Memo

Application Number: S/20/1586

Proposal: Construction of a wider dropped kerb and wider opening into site.

Location: Electricity Substation Garrard Way/ Marshgate Stratton St Margaret

Drawing
 Proposed Site Entrance
 Plan, Section and Details

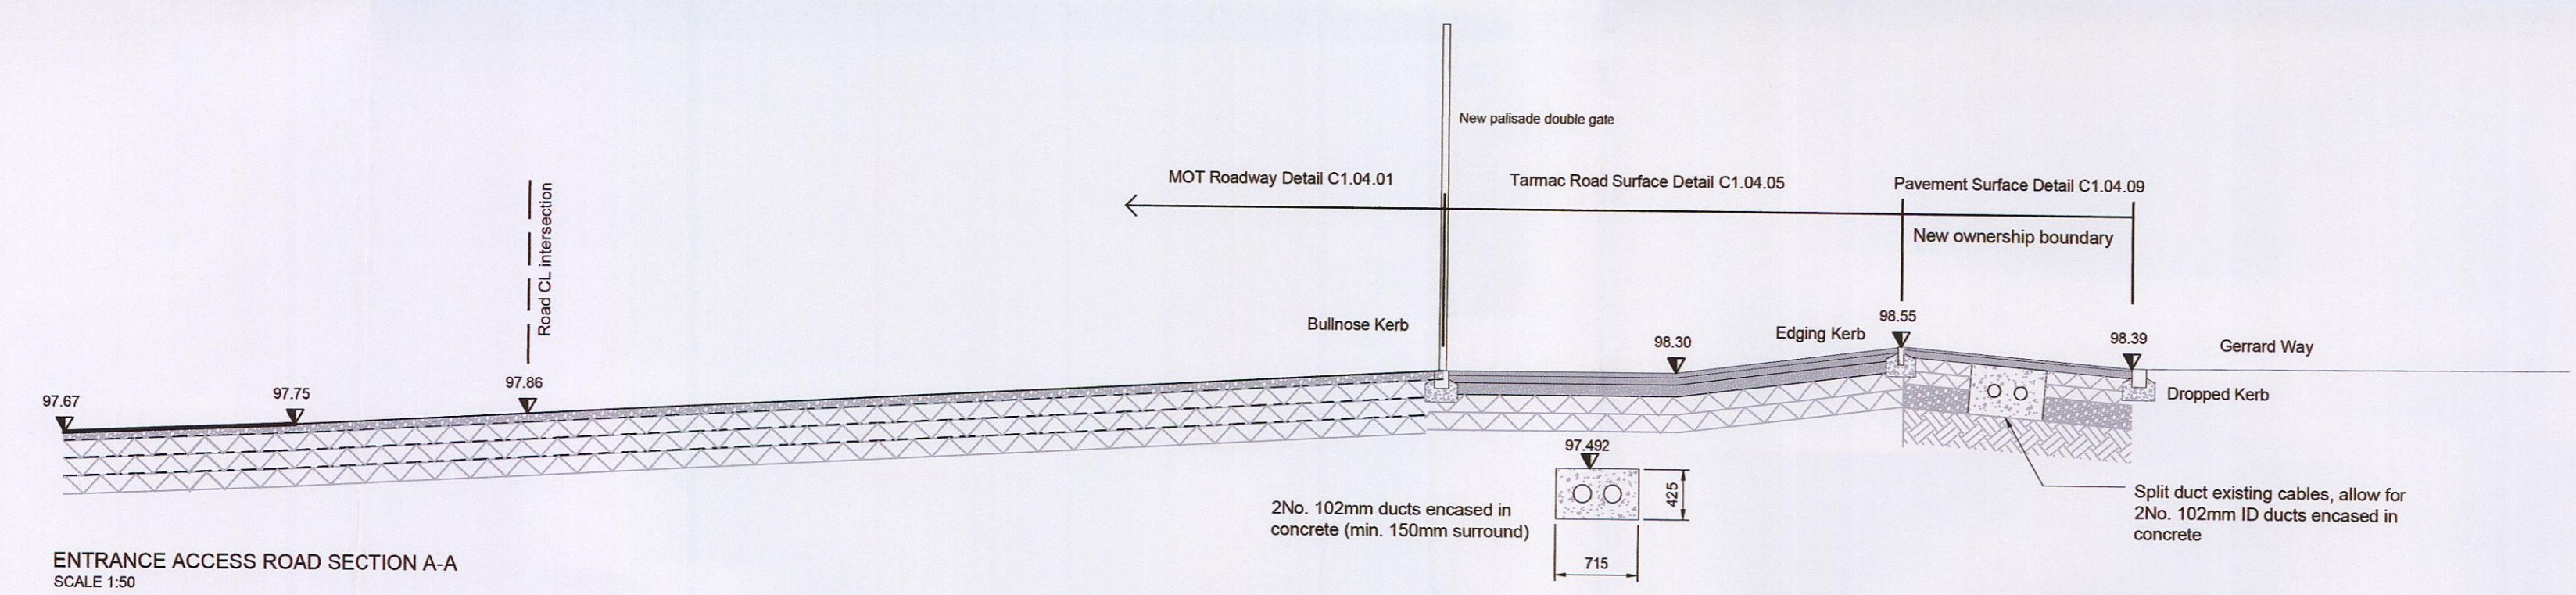
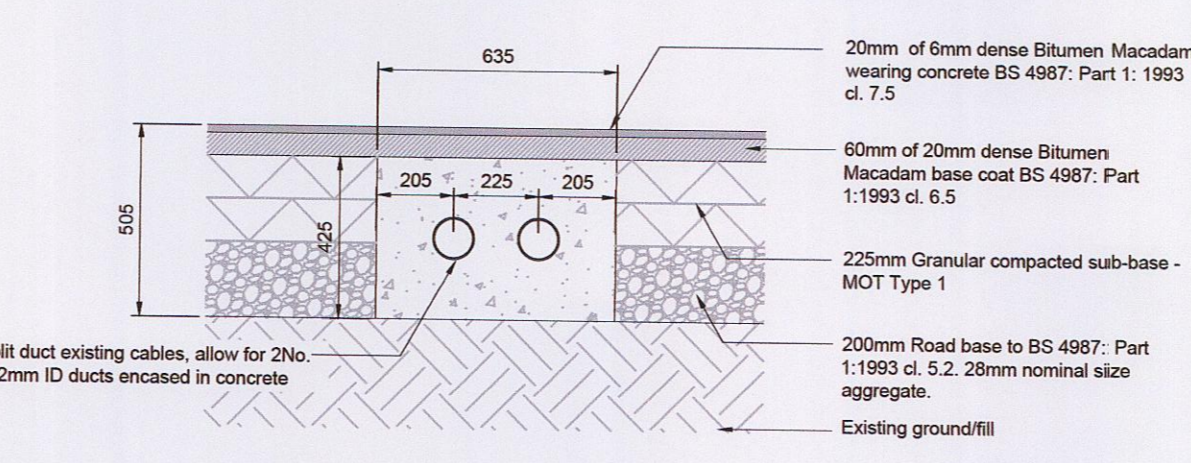
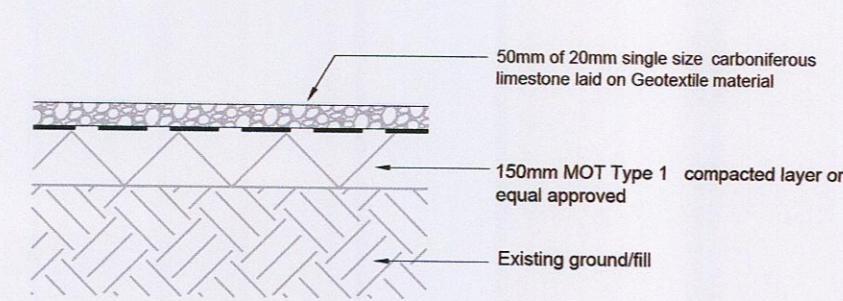
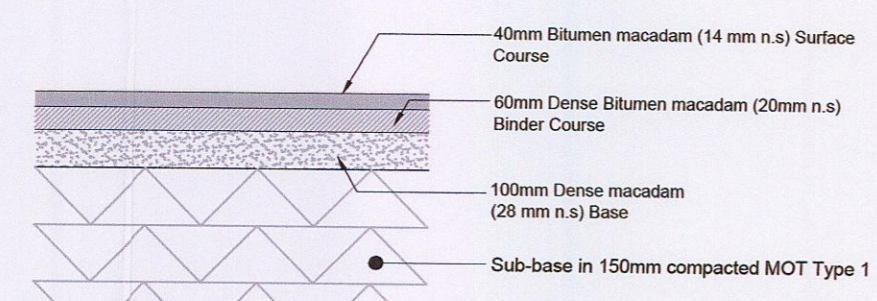
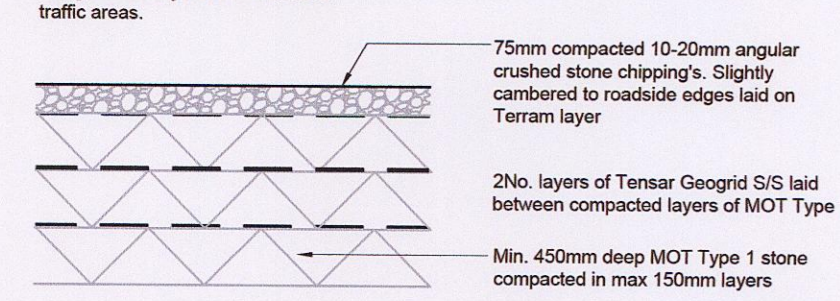
The plans detailing the widening of the existing dropped kerb from single vehicle width and to set the gates back to enable arriving and departing vehicles to park on site without parking on the carriageway, is seen as a highway safety improvement.

Prior to the occupation of the development hereby permitted, the vehicular access shall be laid out and constructed in accordance with the submitted plan [drawing no.25451/04 Rev P4] with any gates situated at least 5m back from the carriageway edge of the public road and hung so as not to open outwards towards the public highway and with the area of driveway within at least 5m of the carriageway edge of the public road surfaced in bound material, and shall be maintained thereafter.
